**Our Case Number: ACP-323849-25**

**Re:** The proposed development is for a mixed use development that seeks the regeneration and adaptive reuse of a strategic brownfield site, as part of the Limerick City and County Council 'World Class Waterfront revitalisation and transformation project' 'Cleeves Riverside Quarter' in the townland of Farranshone More in Limerick City.

Proposed Development – Cleeves Riverside Quarter / Riverside Campus

**Observation / Objection**

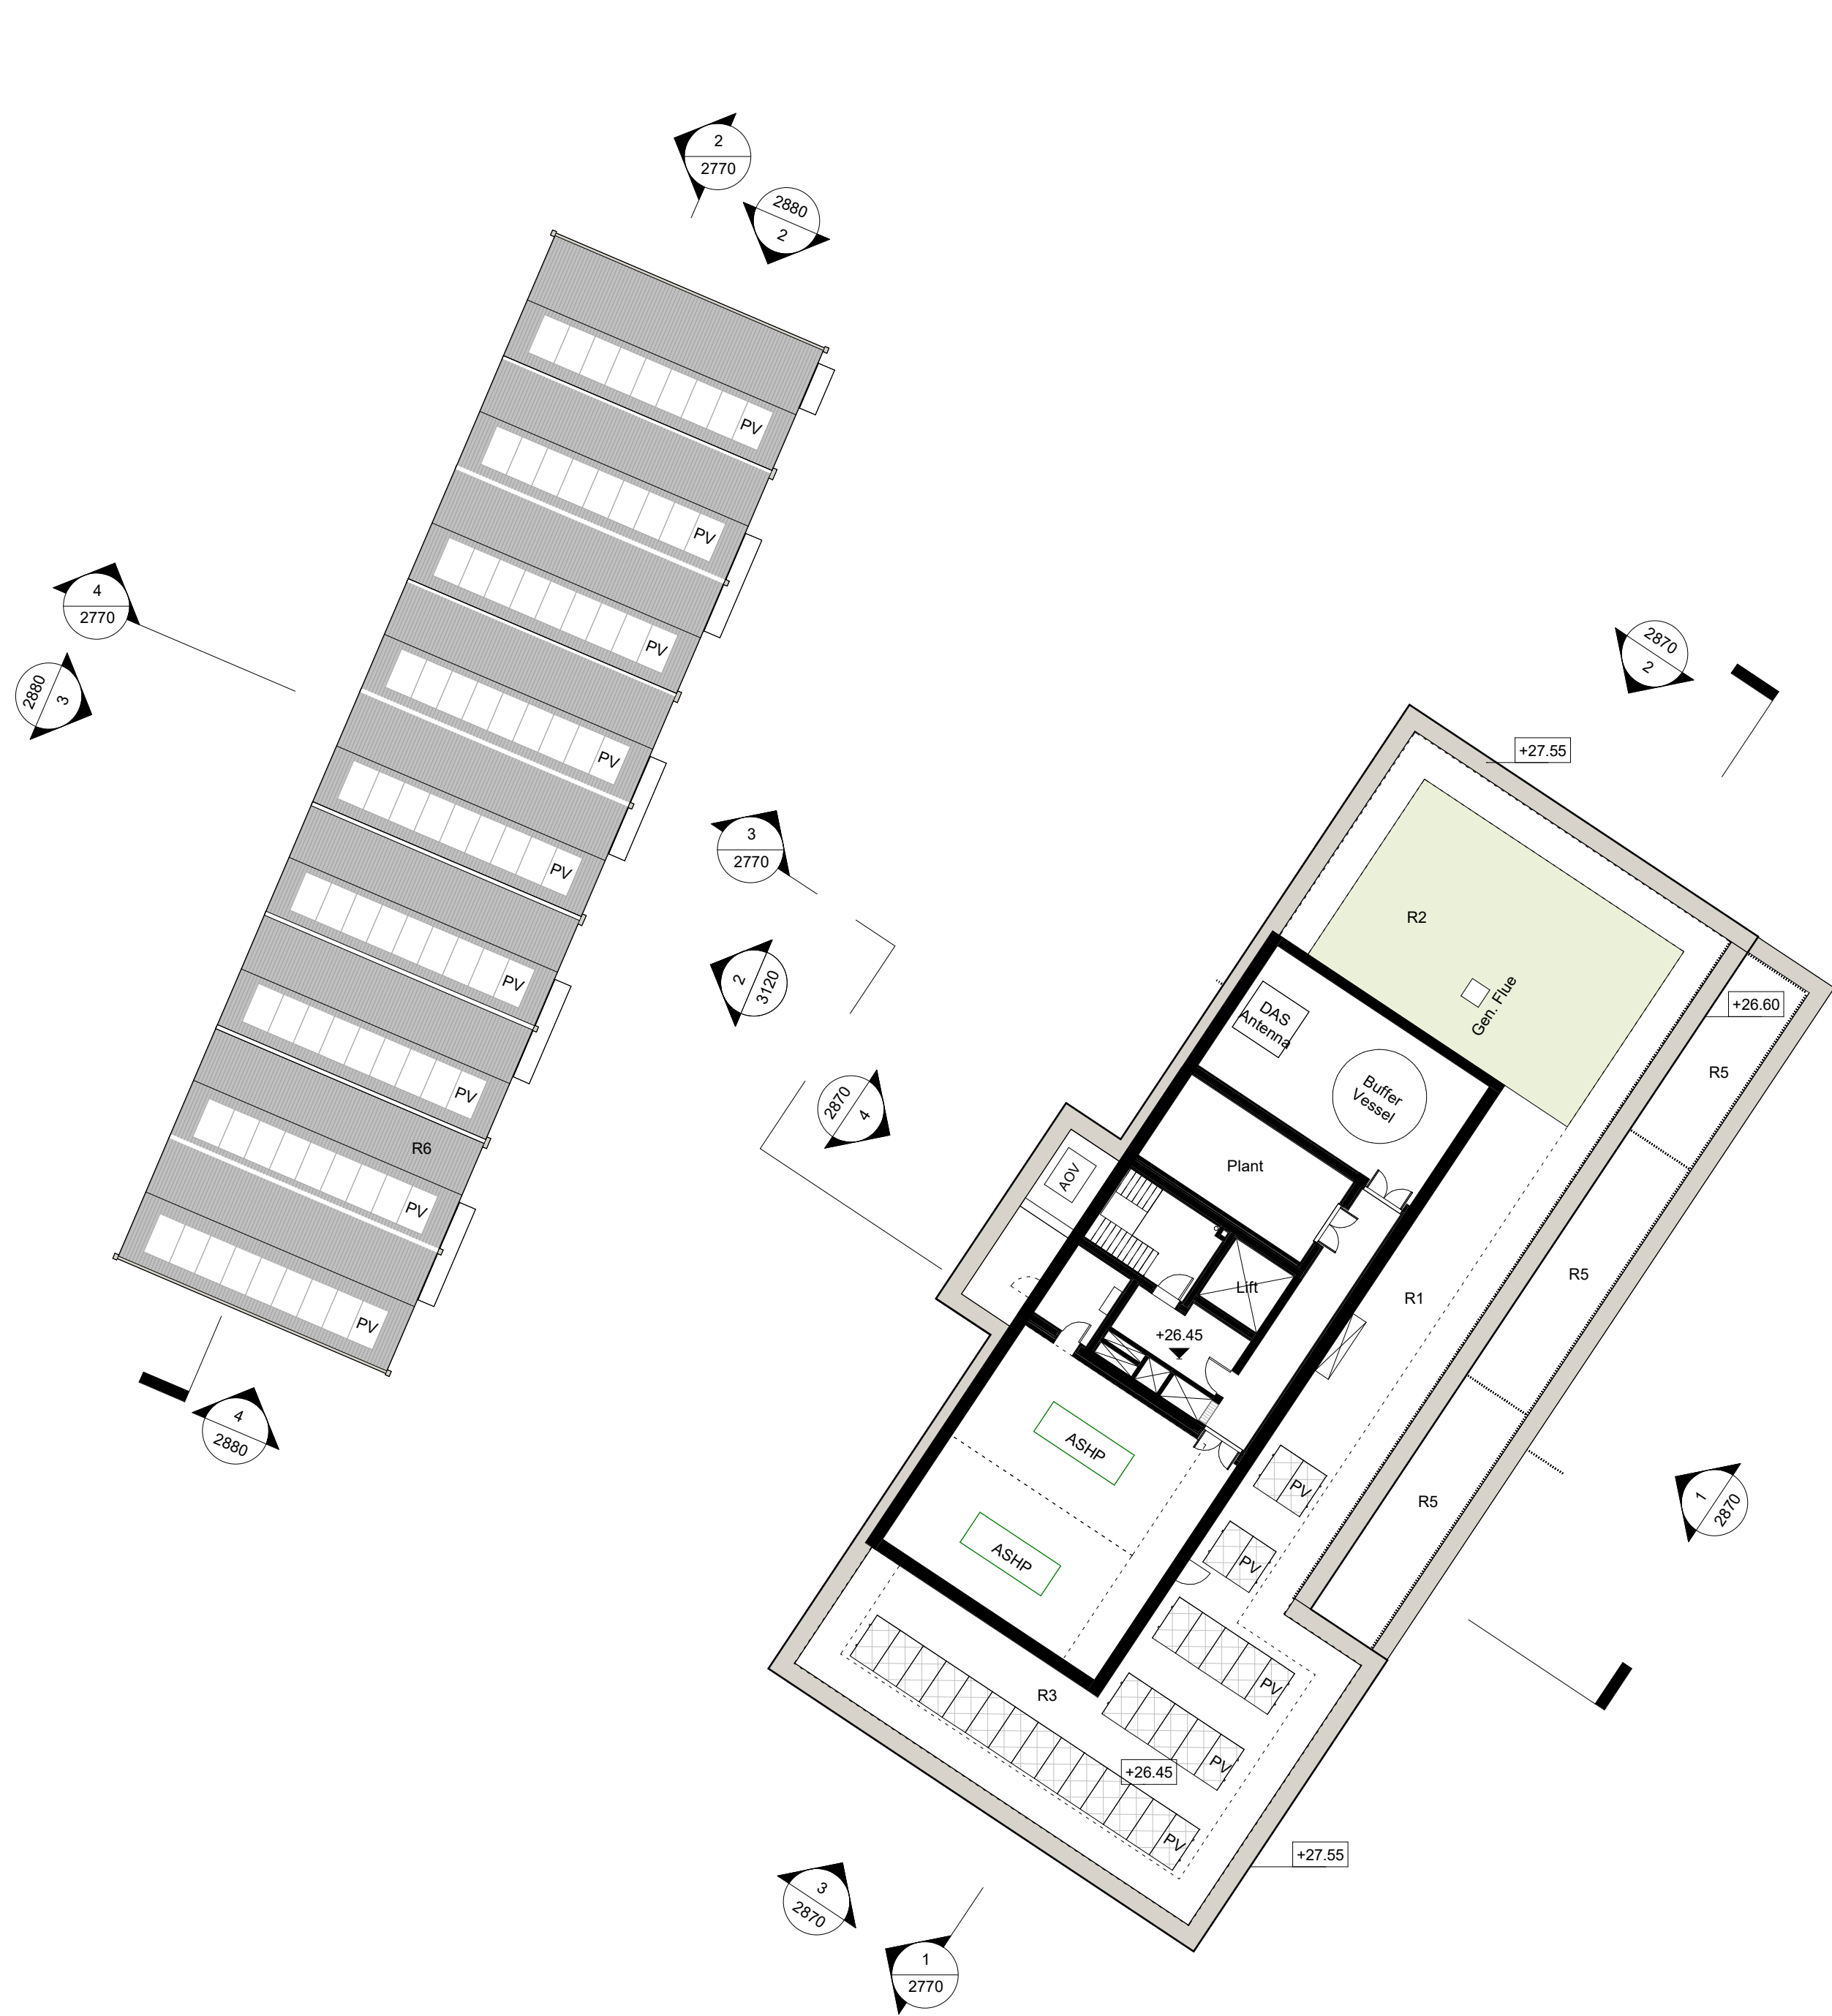
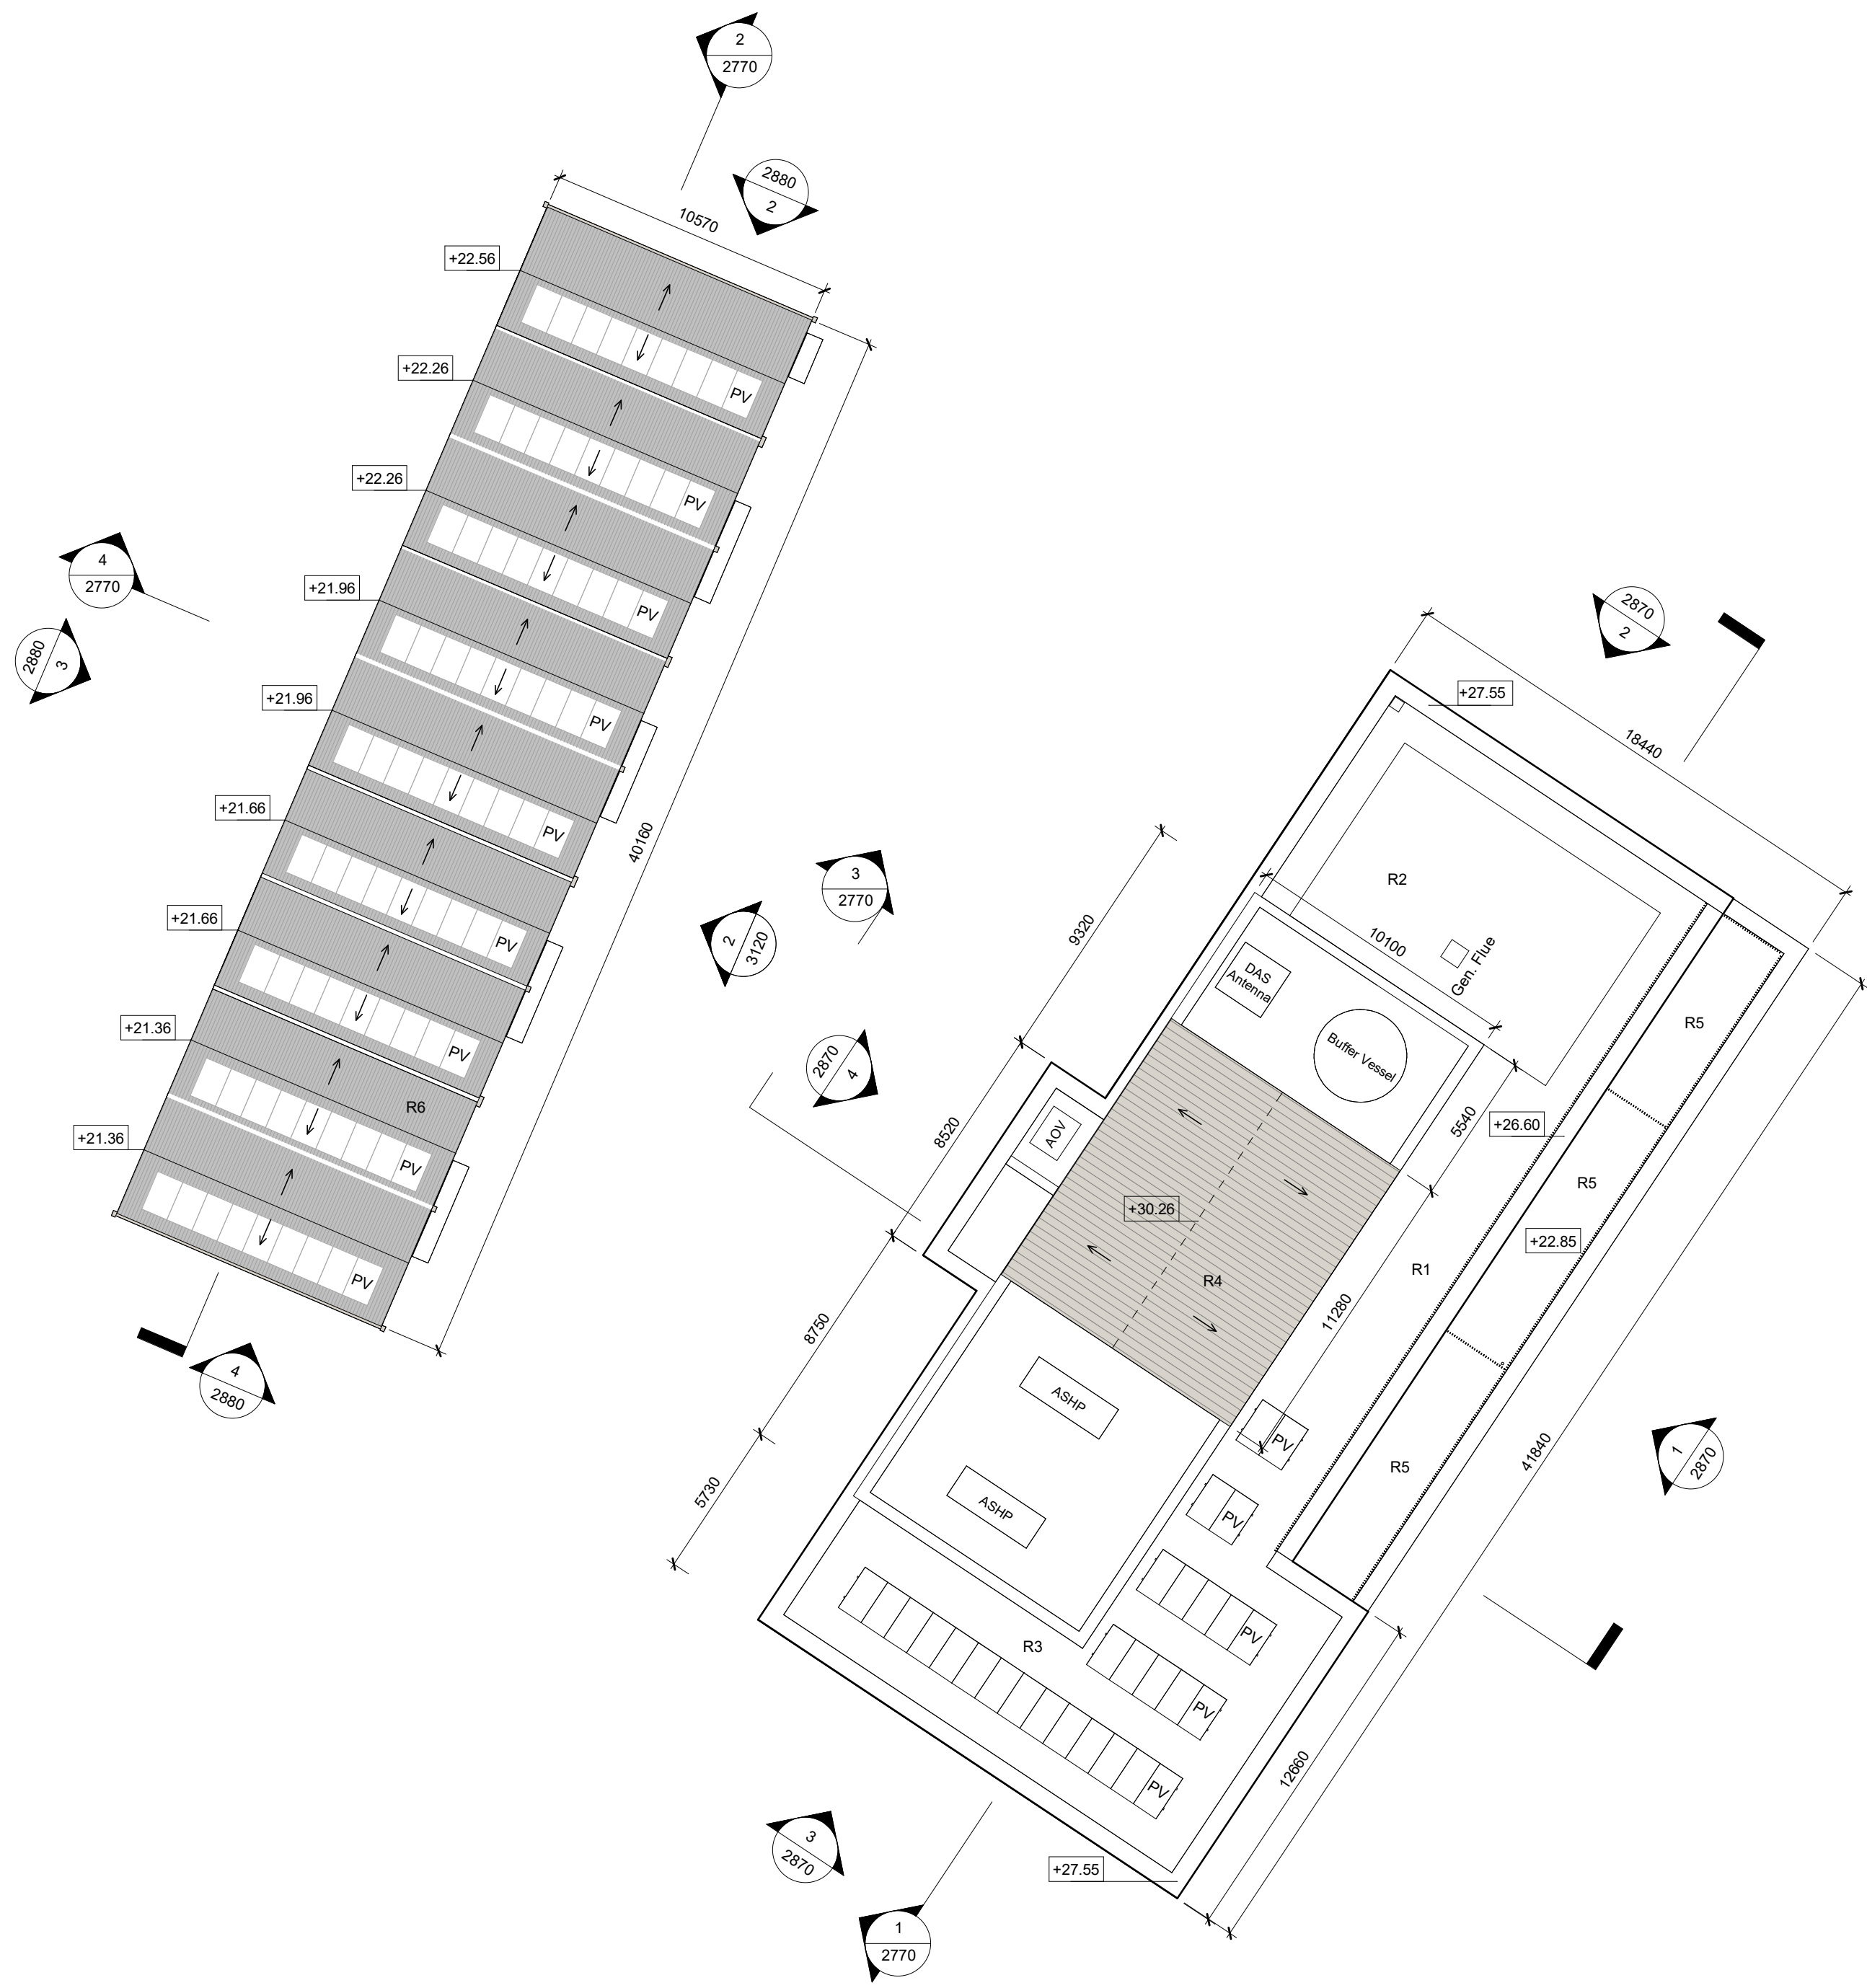
The proposal includes roof-level plant and building services in close proximity to residential properties.

There is inadequate detail regarding:

- Noise levels
- Acoustic screening
- Hours of operation
- Maintenance access

Given the riverside setting and reduced background noise levels, there is a genuine concern that operational noise will adversely affect residential amenity, particularly during evening and night-time hours.

All rooftop plant and mechanical equipment should be:

- Fully enclosed or acoustically screened
- Located away from residential boundaries
- Subject to strict noise limits, particularly during night-time hours
